From: Malcolm Wilkes [REDACTED]
Sent: 11 September 2019 17:17
To: Simon Davis <Simon.Davis@arun.gov.uk>
Subject: Planning Consultation on AW/159/19/DOC

Further to submission of Site Plan dwg no 200, which contains a suitably proposed landscape scheme in terms of species choice, planting density and size at time of planting. **Please request from the applicant for clarity the actual quantity of the planting and hedgerow numbers being proposed** (both laurel and native hedgerow) Once these quantities are confirmed I see no reason not to recommend the discharge of Condition 8 on application AW/159/19/DOC.

Site Plan

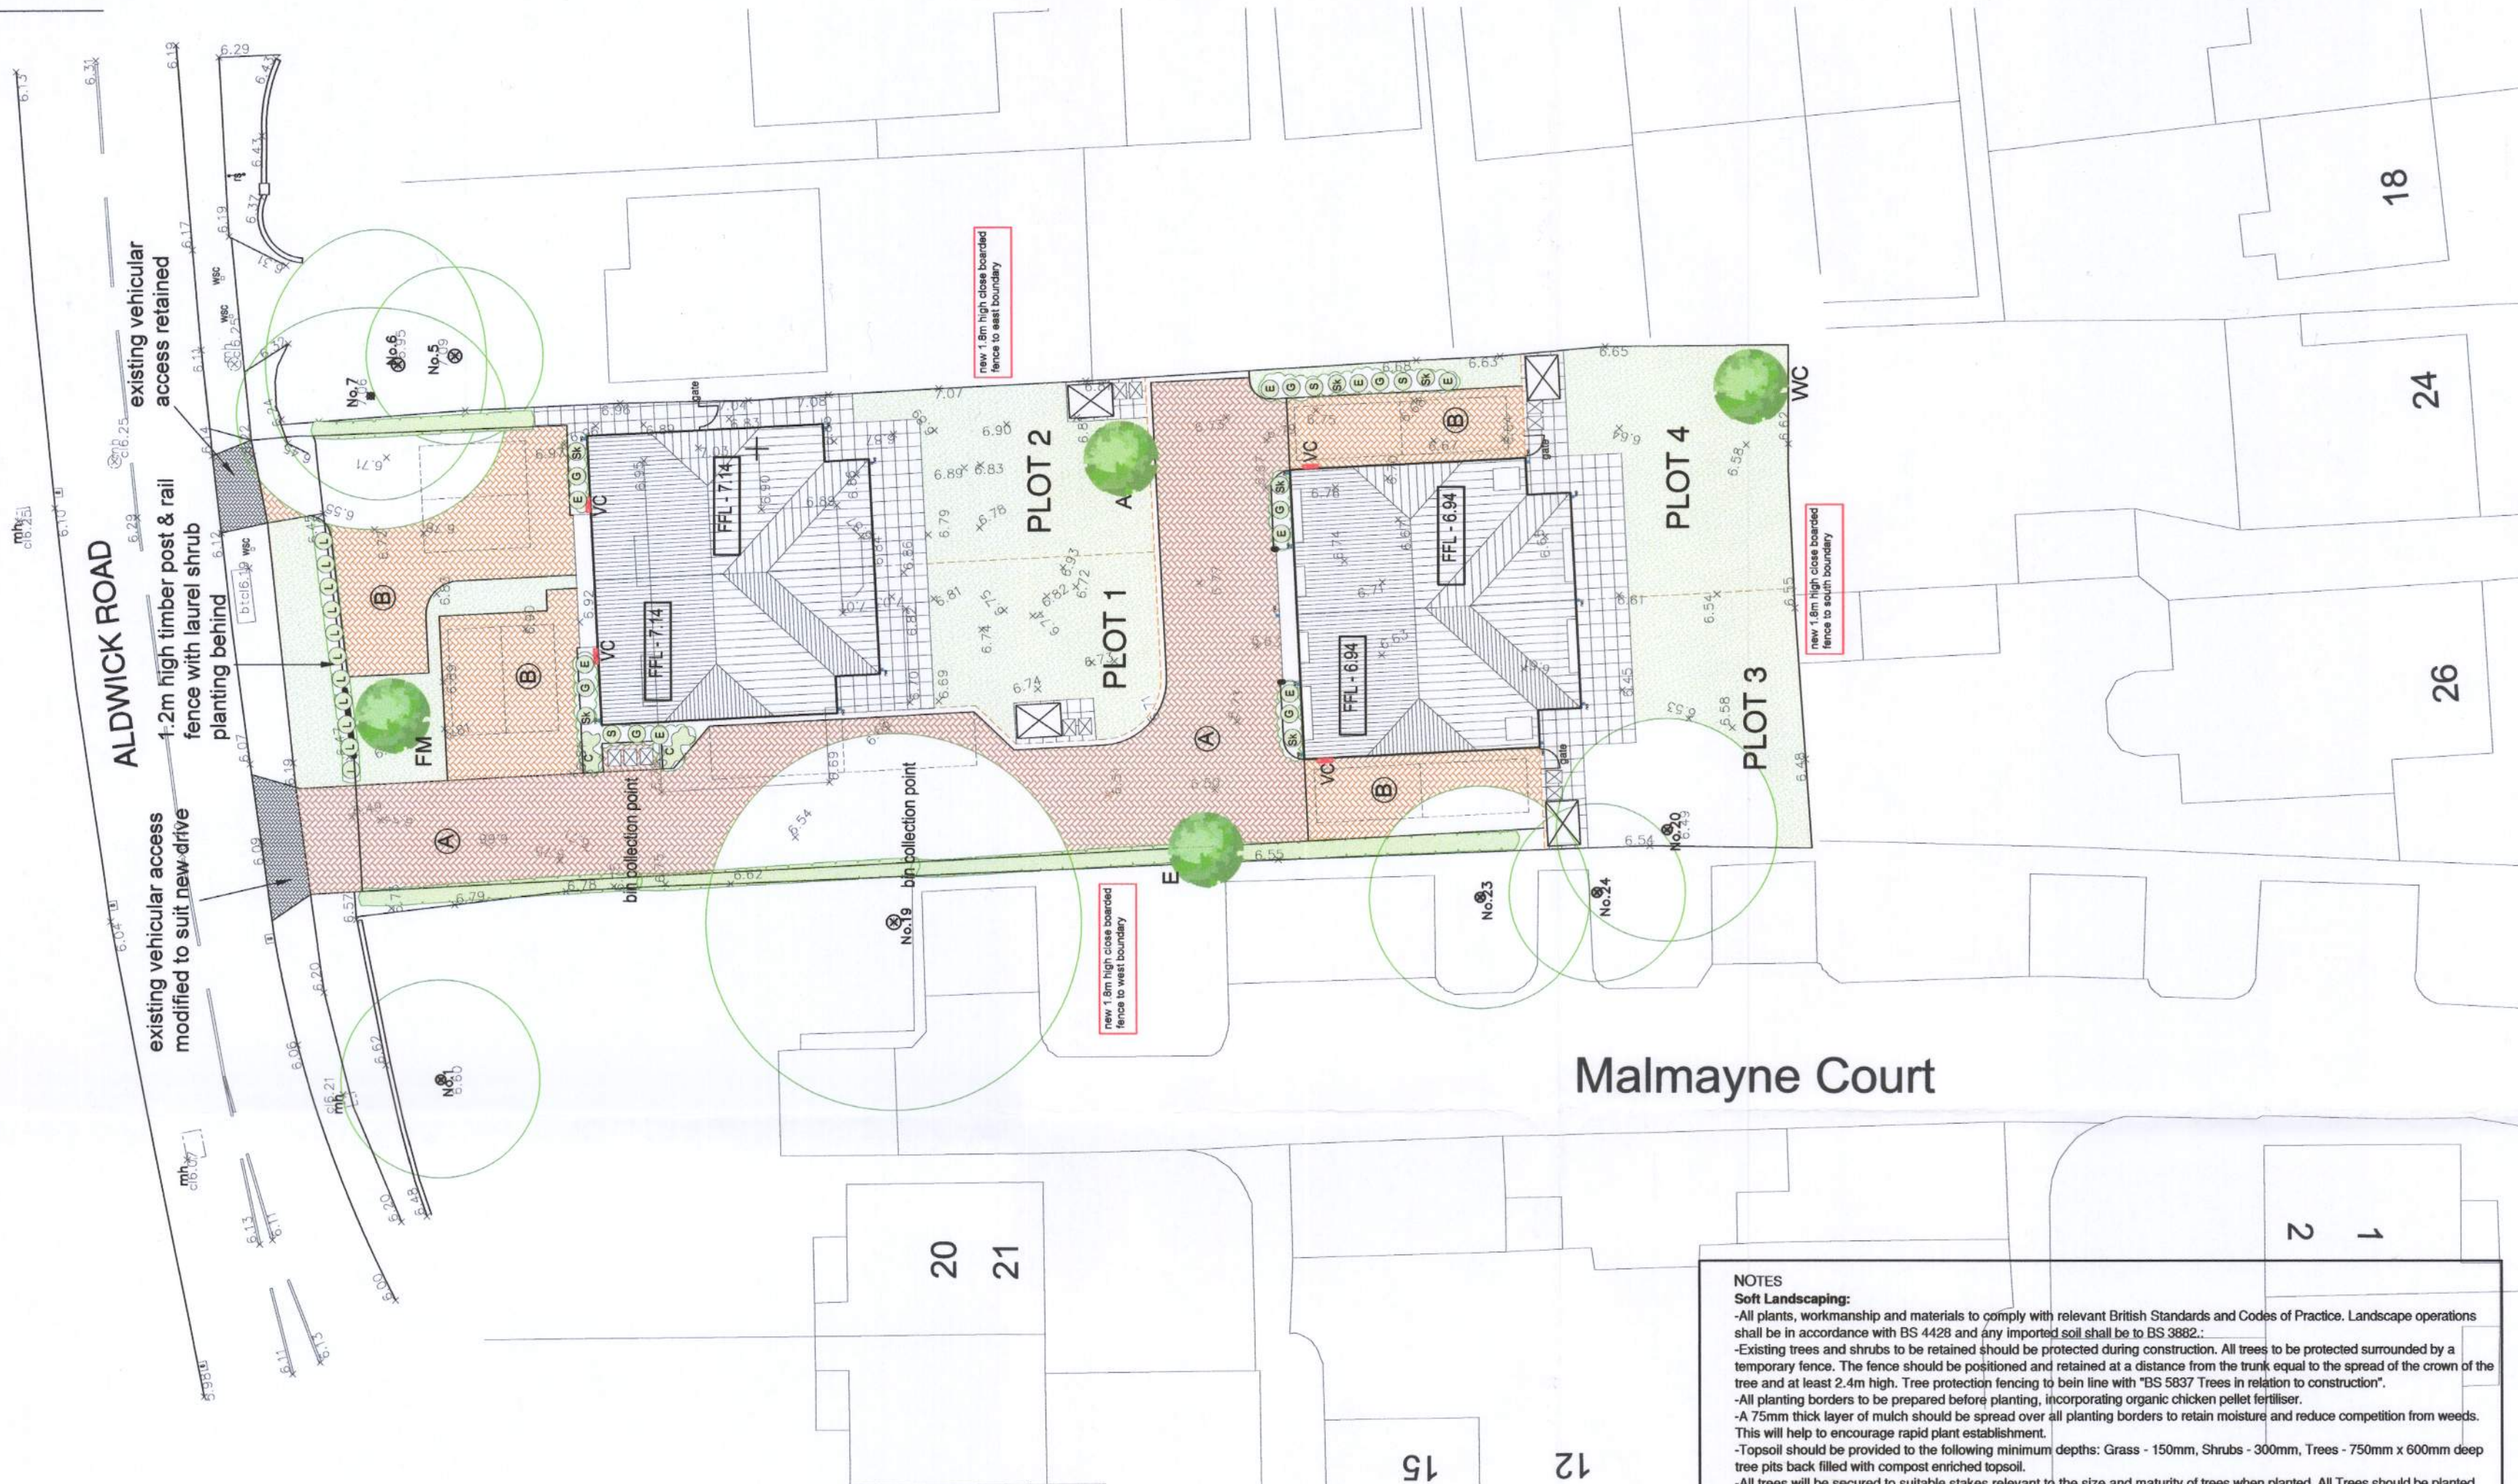
Can you provide the requested information (the actual quantity of the planting and hedgerow numbers being proposed - both laurel and native hedgerow) either separately to or on an updated Landscape Plan please. I can then discharge the condition.

The planting information for the laurel hedge and native hedge is indicated on the drawing

- Laurel hedge planting – to be planted at 600mm spacing
- Native hedge planting – 50% hawthorn, 30% holly, 20% field maple. Plants to be 90-120cm tall ??/ planted as a double staggered row. All plants 450mm apart
